Bramford to Twinstead Reinforcement

Document 8.8.5: Applicant's Comment on Other Submissions Received at Deadline 5

Final Issue A
December 2023

Planning Inspectorate Reference: EN020002

### AB-AP5

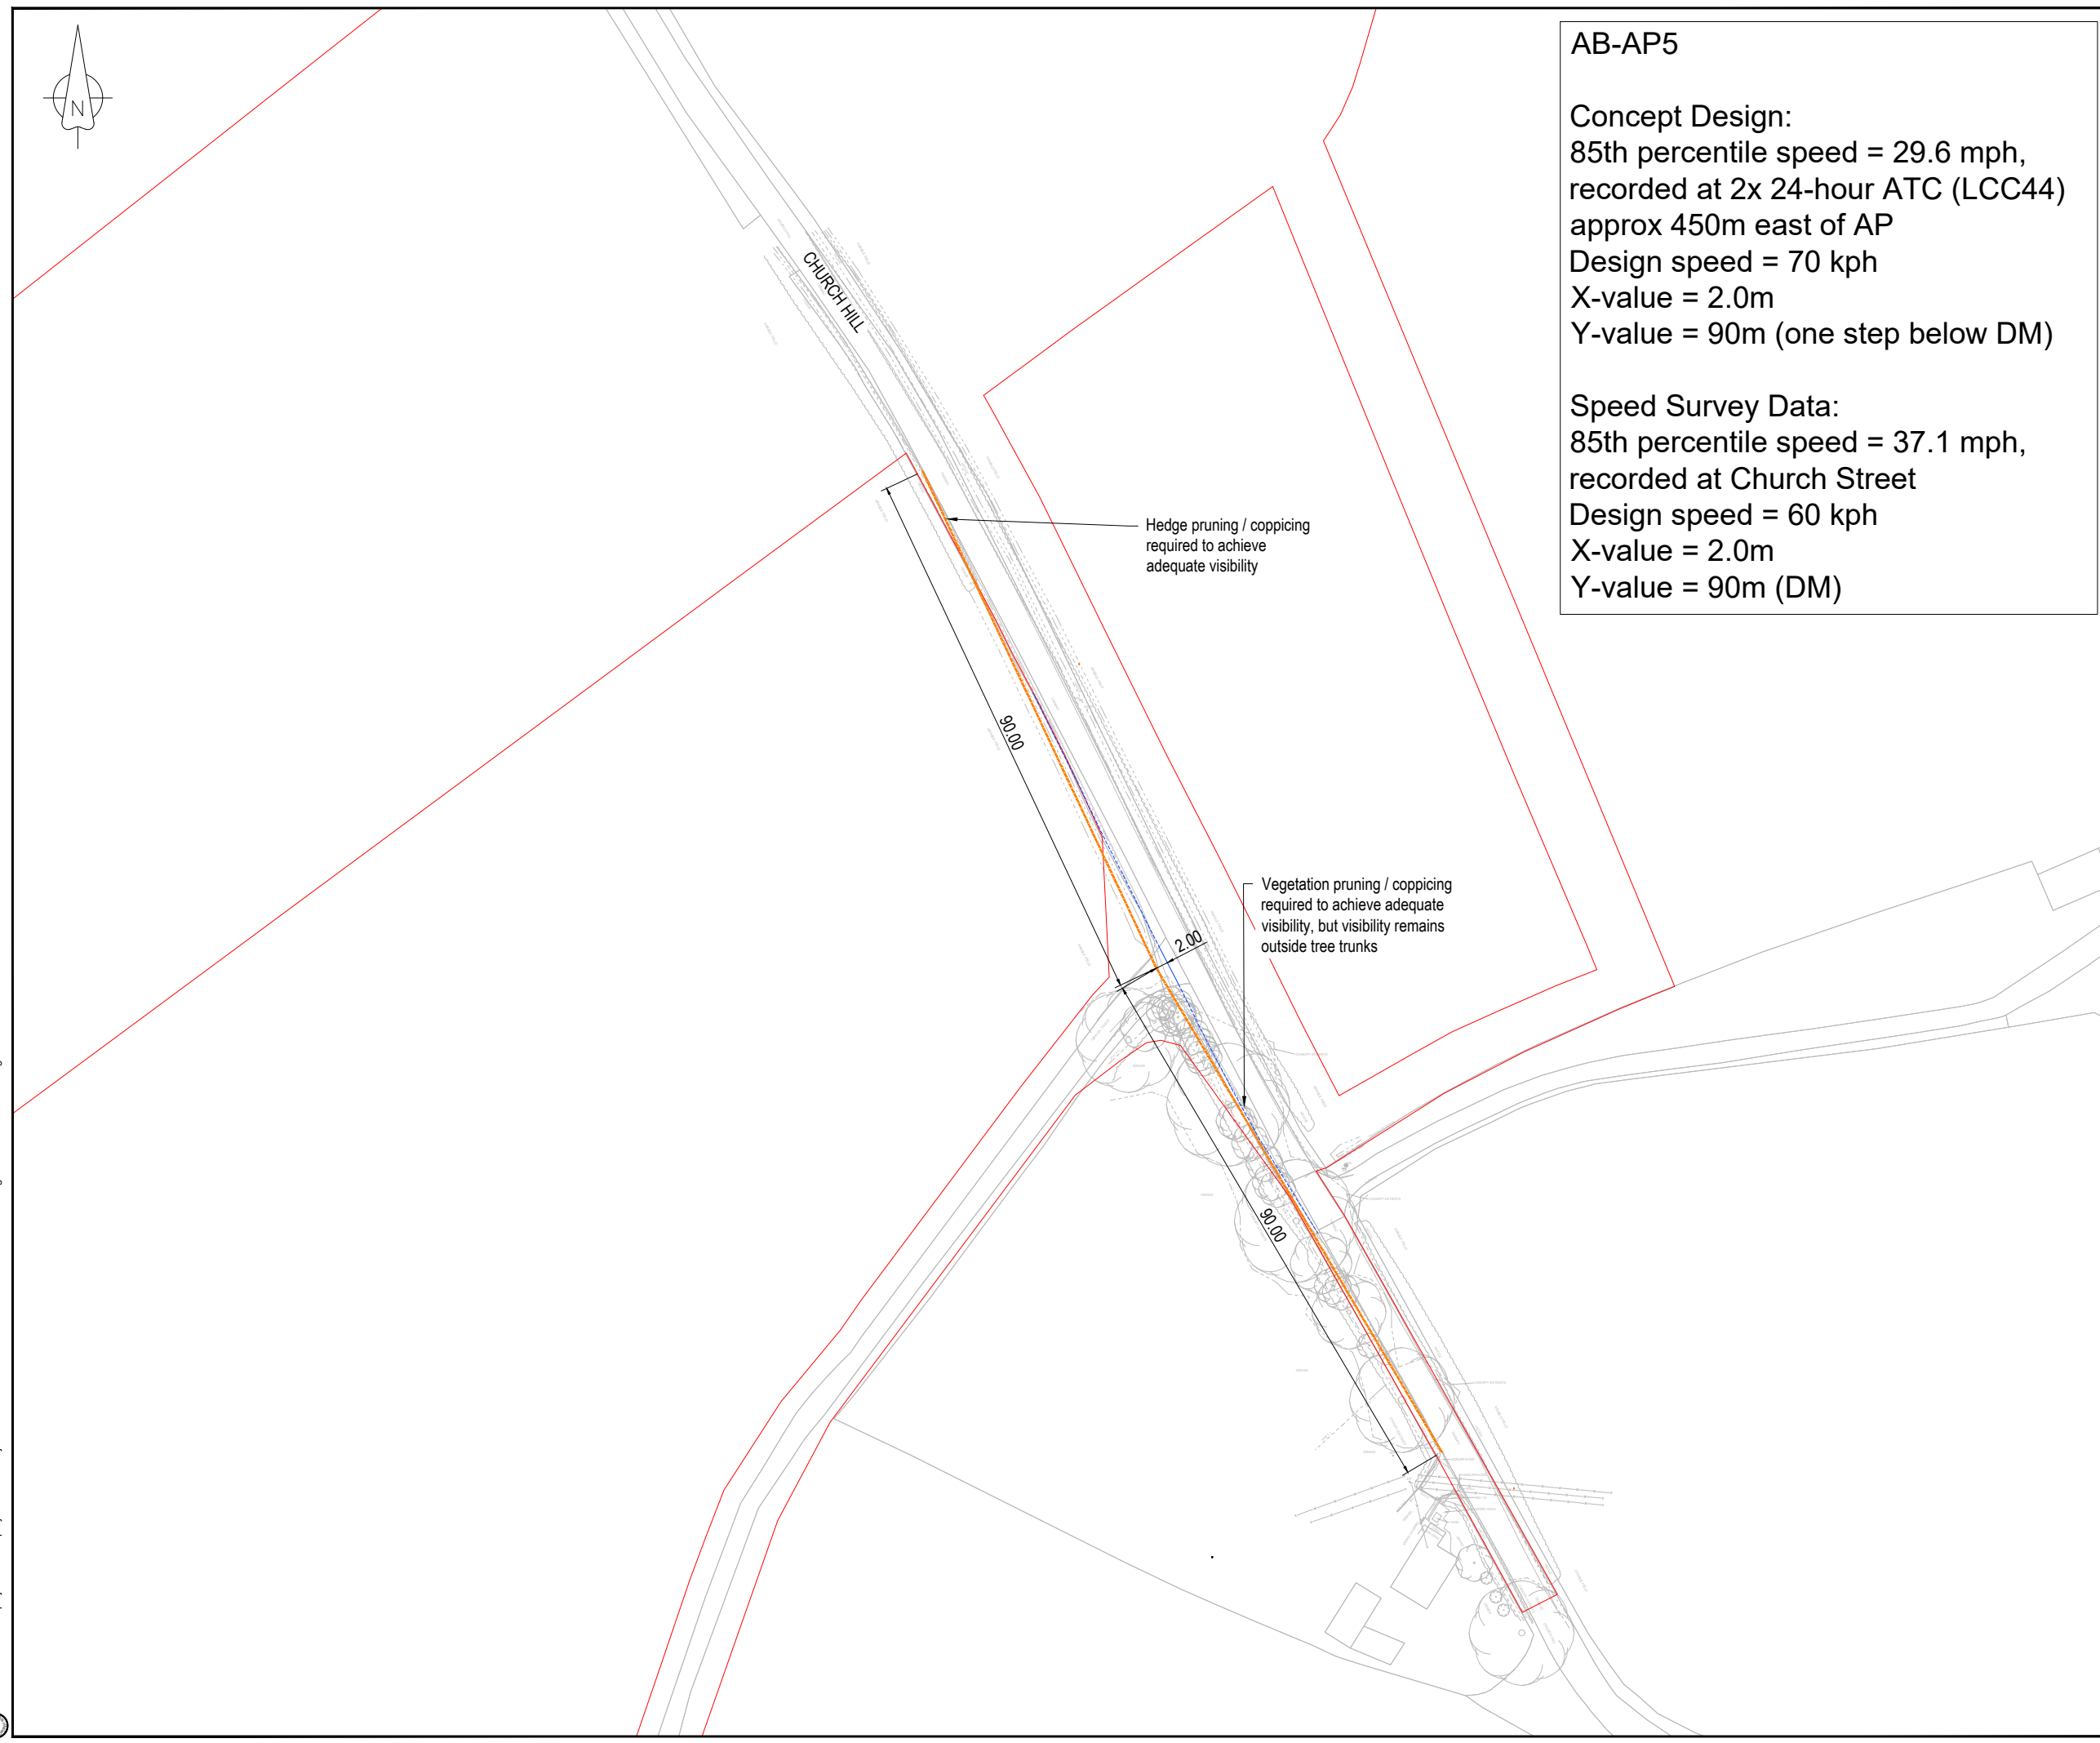
- 2.8.13 In Table 9: SCC Table of Comments on 8.6.2.3 Applicant's Written Summaries of Oral Submissions to ISH, [REP4-050], under 3.1 Local Impact Reports and the Transport Assessment, SCC notes that the LHAs have yet to receive any detailed plans of accesses; however, at a meeting on the 29 November 2023, the Applicant confirmed that the plans are in preparation and will be shared as completed.

- 2.8.14 In SCC submission Comments on any other submissions received at Deadline 4 [REP5-030] under 6.2. Any Other Matters Arising from the Responses to the Examining Authority's First Written Questions SCC noted the submission of [REP3-005] (the indicative bellmouth design approach) by the Applicant. Suffolk County Council remains greatly concerned regarding the feasibility of many accesses and that the site-specific assessments have not been completed in sufficient detail.

- 2.8.16 The sketch showing access point AB-AP5 adjacent to Rose Cottage was shared directly with LHAs on 06 December and has been put into Examination at Deadline 6 (Appendix 1 of **document 8.8.3**).
